Your ref:
Our ref: 21/00596/F
Please ask for: Mrs Lesley Raby
Direct dial: 01553 616818
Direct fax: 01553 616652
E-mail: borough.planning@west-norfolk.gov.uk

Details: **New enclosed porch to side of dwelling at Charnwood 12 Cedar Grove North Runcton King's Lynn Norfolk**

# Proposed Porch

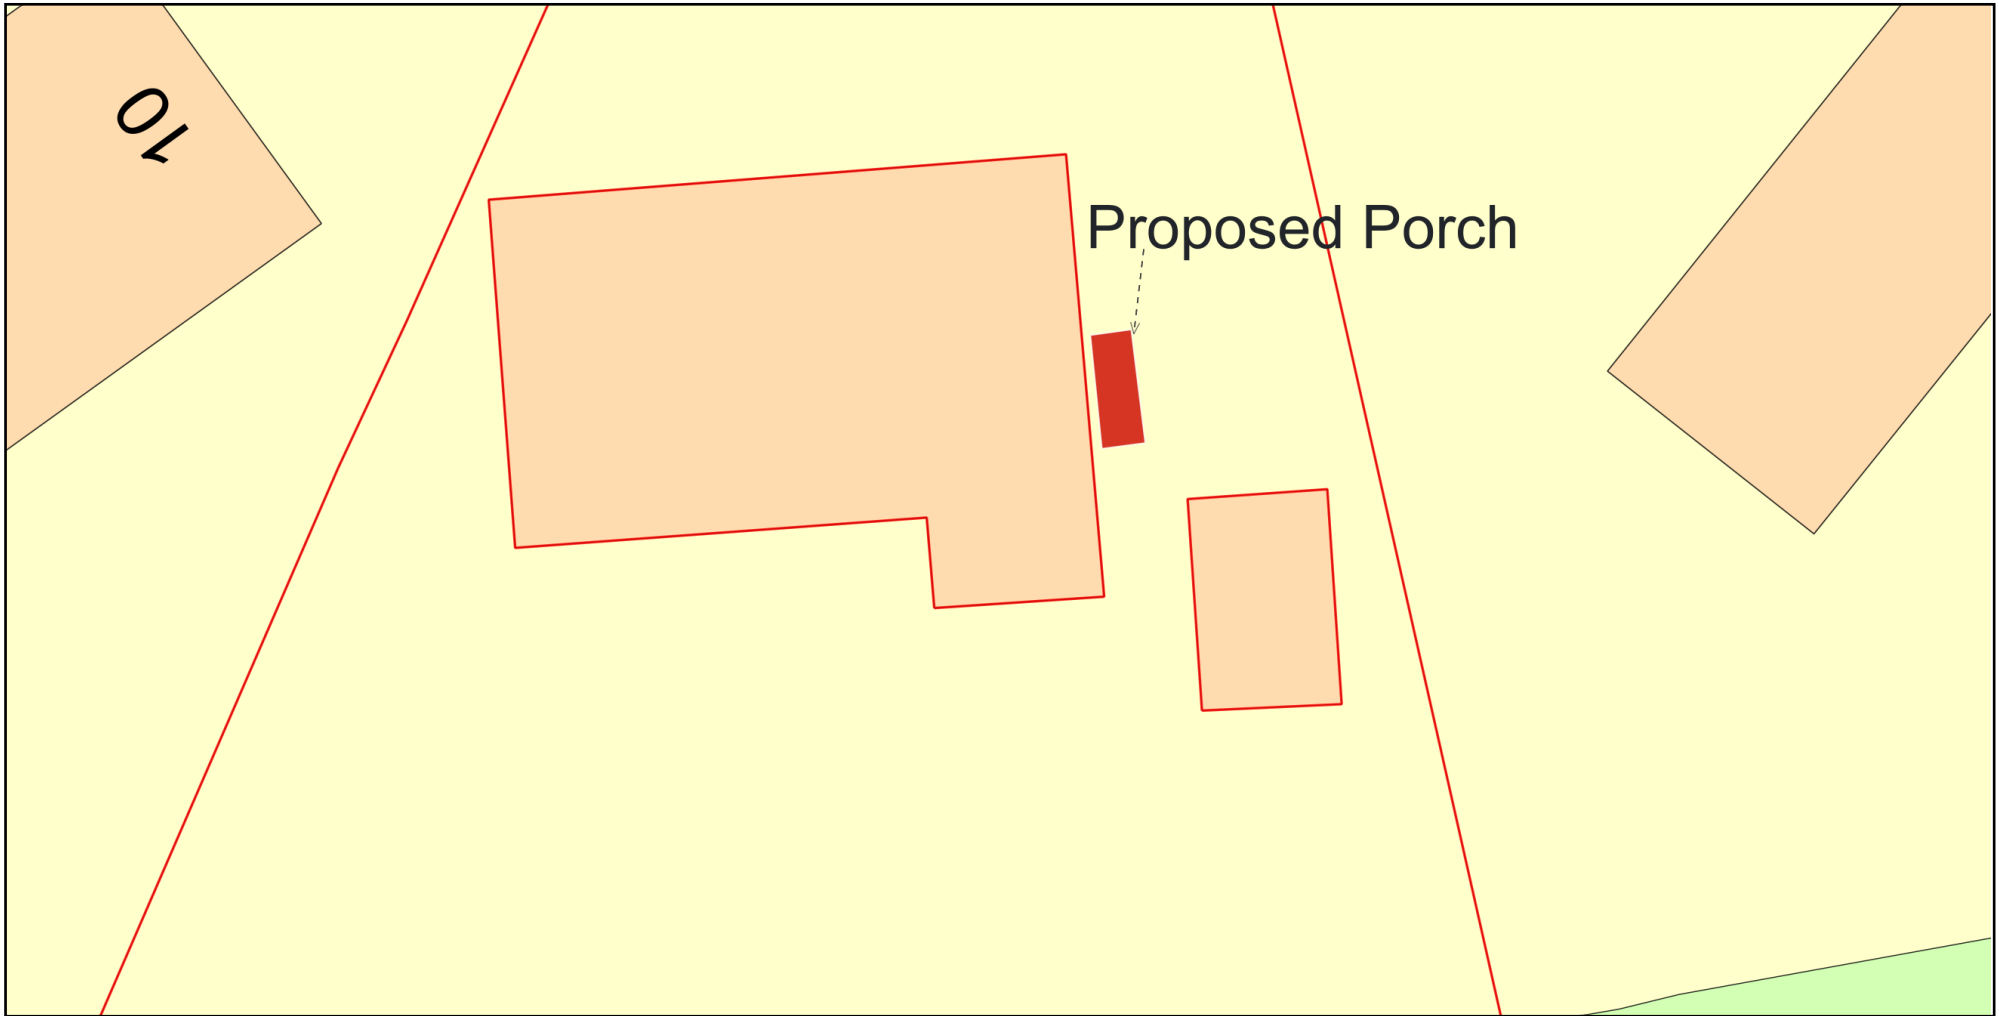
1. Please confirm the floor level with match existing and that the site levels will remain as existing.
2. Provide a roof plan of the porch
3. The block plan needs to show the porch attached to the dwelling and plotted to scale
